# PORTLAND MAINE

Public Services Department  
Michael J. Bobinsky, Director

April 23, 2013

Re: 223 Western Promenade

Landscape Plan
 223 Western Promenade
 223 Western Promenade, ME

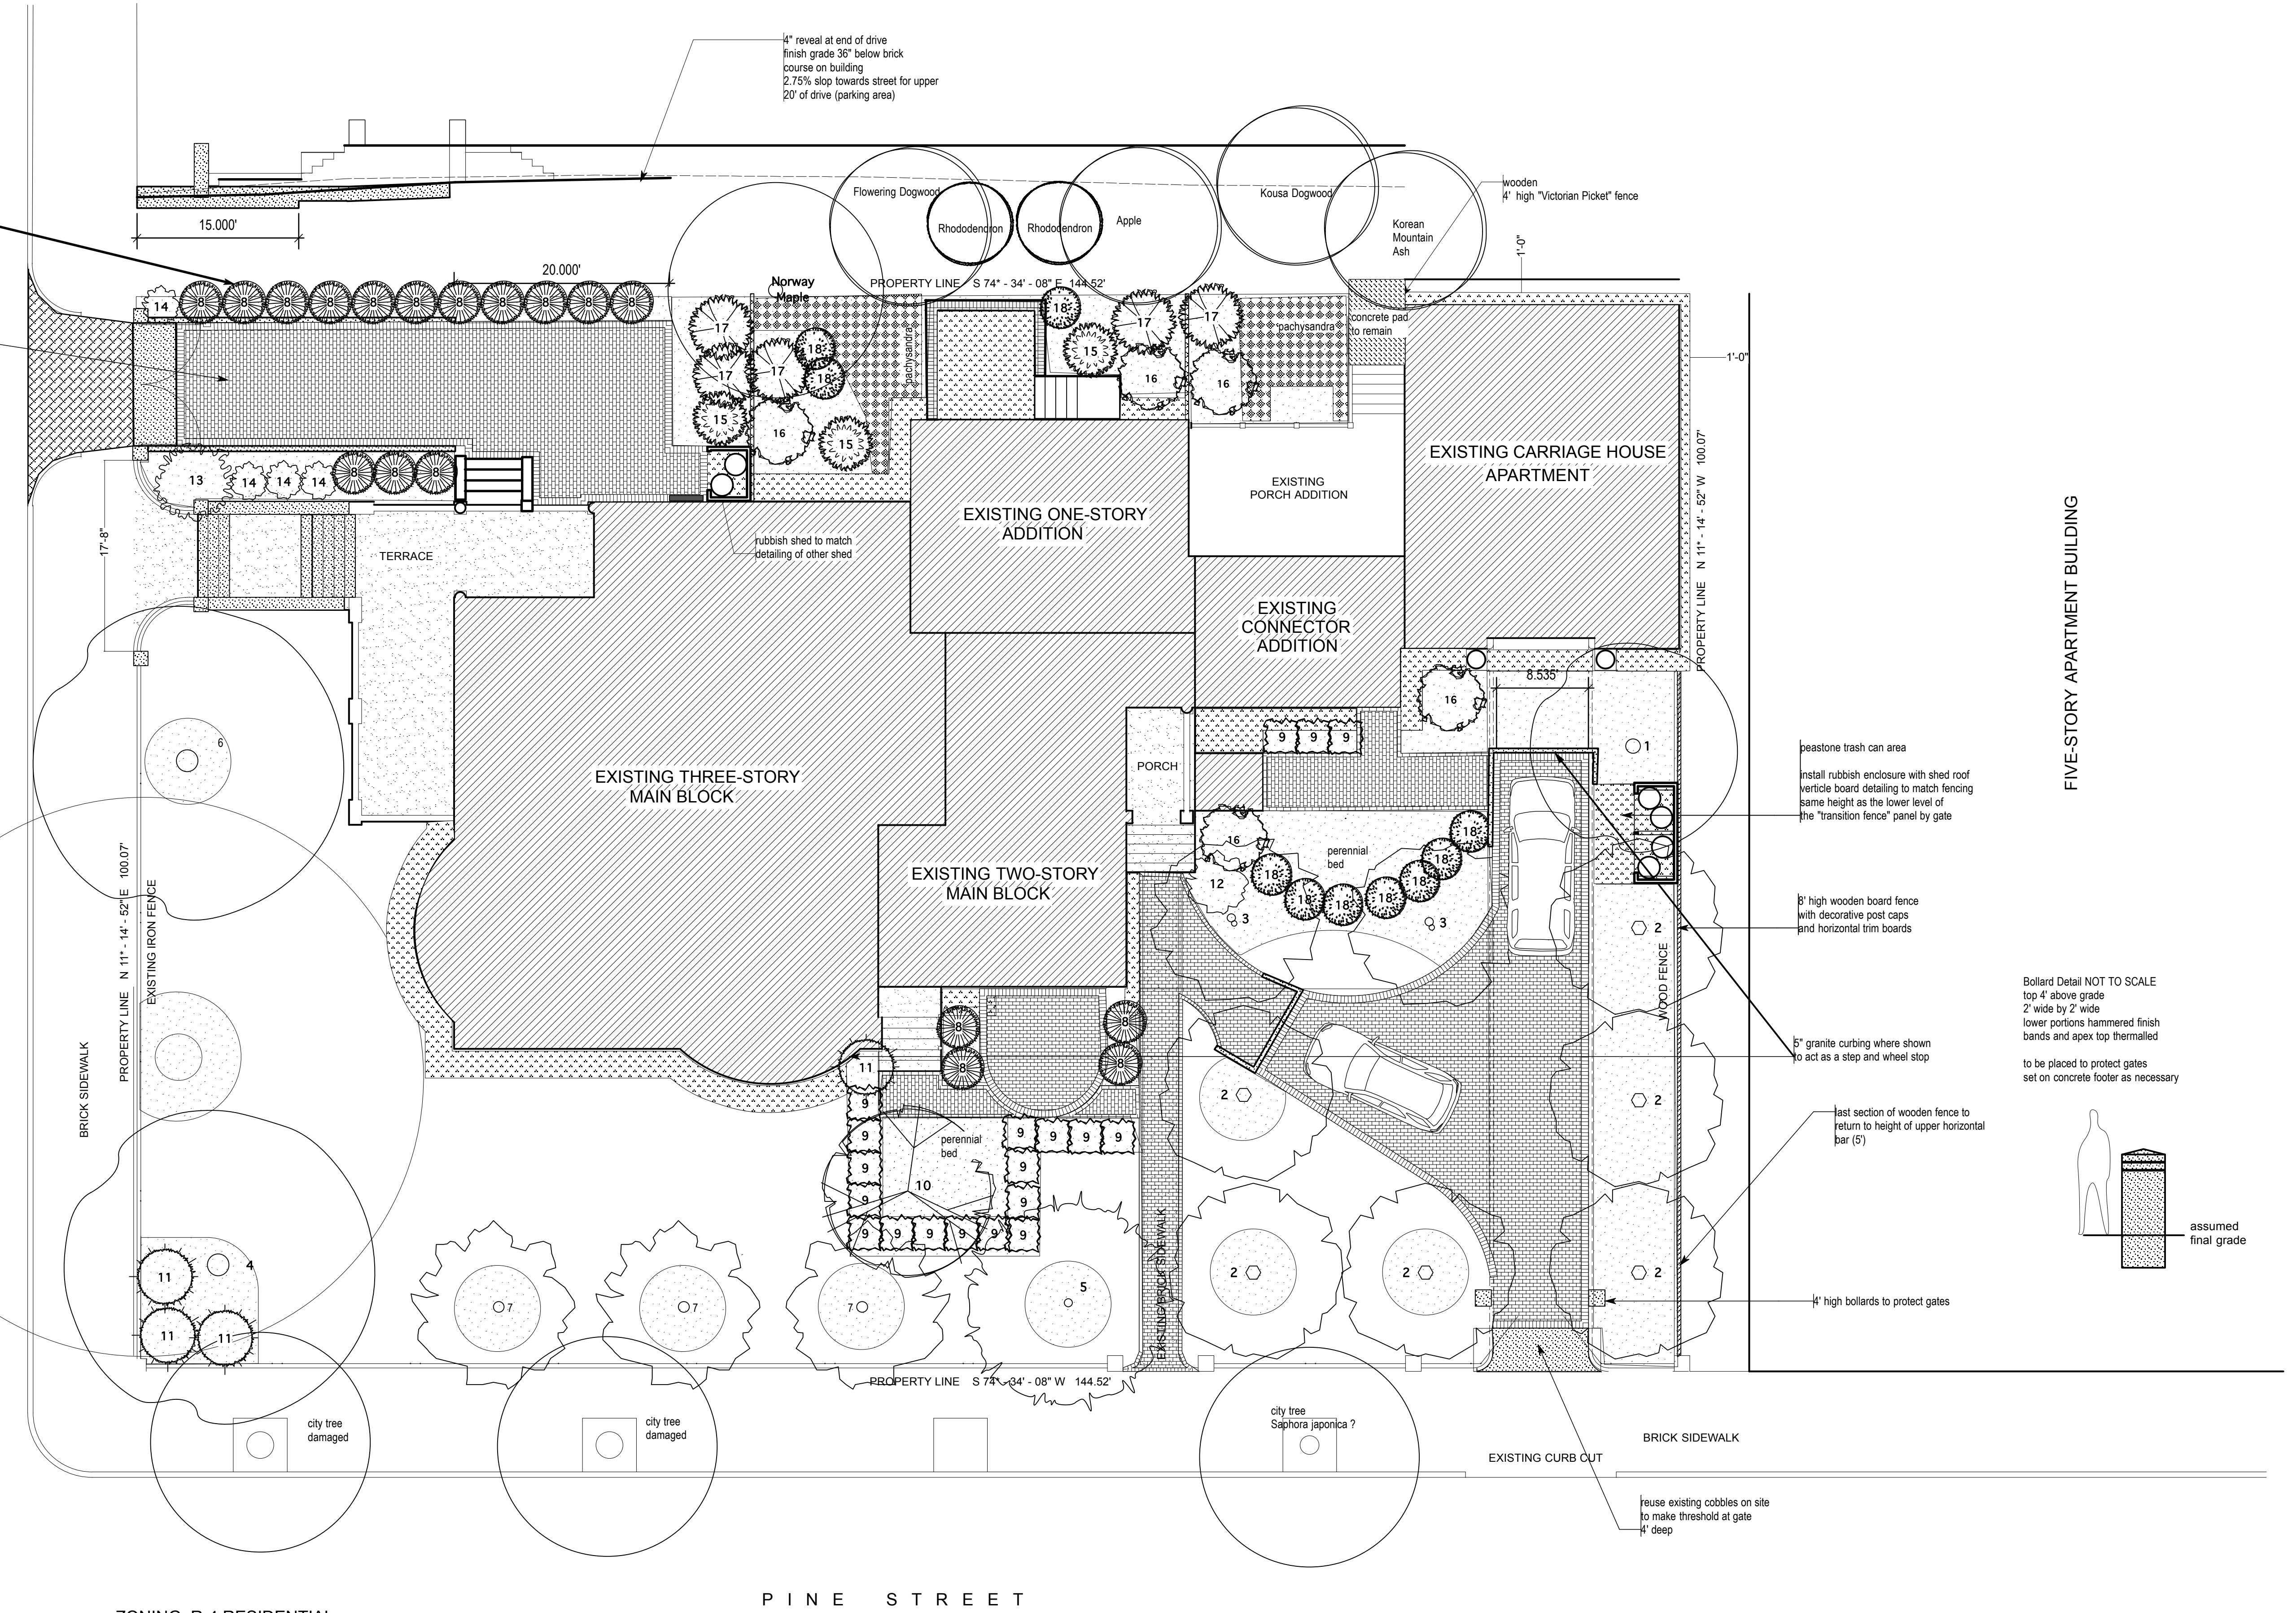
It is understood that you have requested a waiver of the City of Portland's Design and Technical standards as it relates to driveways. Article #1.7. DRIVEWAY DESIGN, provides guidance for the design and installation of driveways. Within this Article it states that only one driveway shall be allowed per property. It is understood that your development expansion which required Historic Preservation review and approval, provided parking modifications off of the existing driveway from Pine Street, and the site plan also reflected a second driveway access off of Western Promenade to accommodate a single parking space. The Historic Preservation Board approved the site plan with the second driveway access and the Planning staff referred the second driveway to the Department of Public Services for final authorization. Department staff denied the second driveway access due to inconsistency with the City's approved driveway standards. In denying the access, it was suggested that the development could be subdivided and that the subdivision would have created two properties with each being allowed a driveway access. That was not pursued and you sought an appeal to my office of our staff denial of the second driveway access.

In reviewing the site plan and in discussing further with staff, it was concluded that adding this single space to the modified angled parking off of the existing driveway access from Pine Street would not be practical due to remaining space considerations available and maintaining efficient access to the main entrance of the property. Following review with staff, I noted that there would be no adverse public safety impacts from allowing this second driveway access off of Western Promenade.

In addition, the proposed driveway is along the local frontage road portion of Western Promenade that runs between West and Pine Streets; as such, the implications of this driveway will likely be minimal on the City's transportation needs. For these reasons, I will allow the driveway access permit to be granted as this is unique and specific to this location and not to be interpreted as a precedent for future development. You may work with members of our Engineering staff on finalizing details of the driveway permit.
